State of Washington
DEPARTMENT OF FISH AND WILDLIFE

July 22, 2024

SUBJECT: WDFW COMMENTS ON PD-24-00001 ROSLYN RIDGE WEST

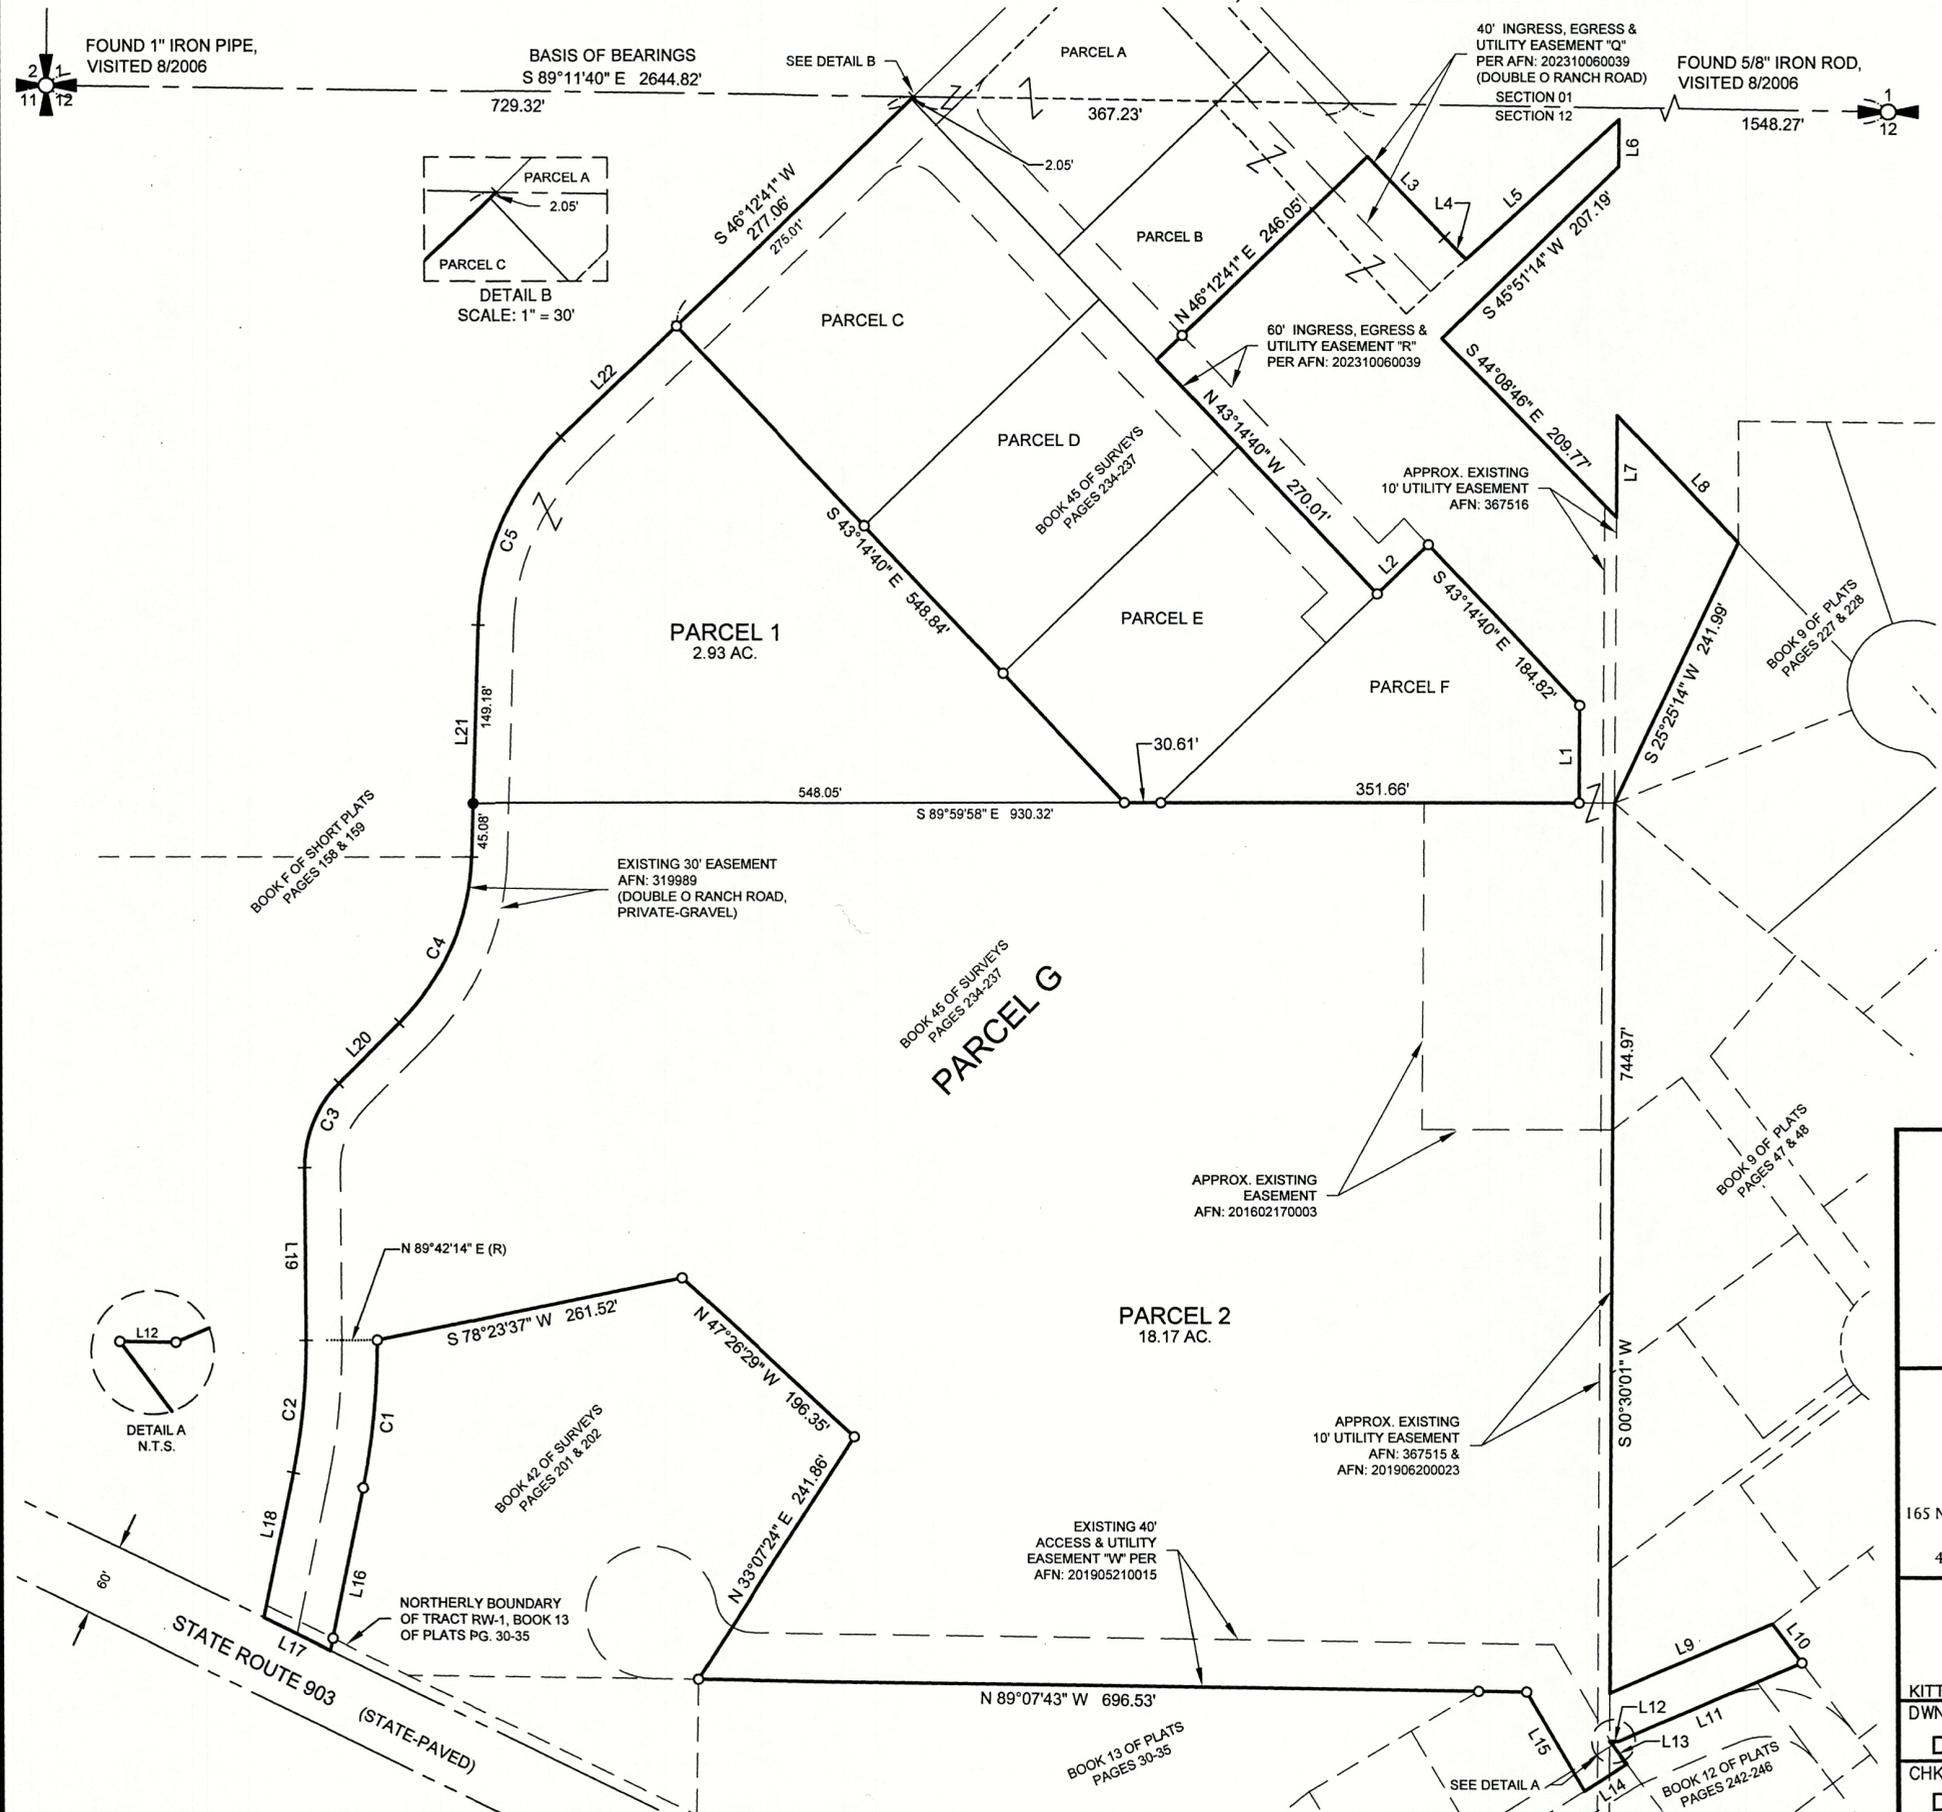
WDFW recommends that all streams and their riparian management zones or buffers be identified on the plat maps; KCC 17A.04.030 identifies a 50' buffer on Ns streams. We also request that prior to any road building or grading near the streams, you contact WDFW to determine if a Hydraulic Project Approval (HPA) is required.
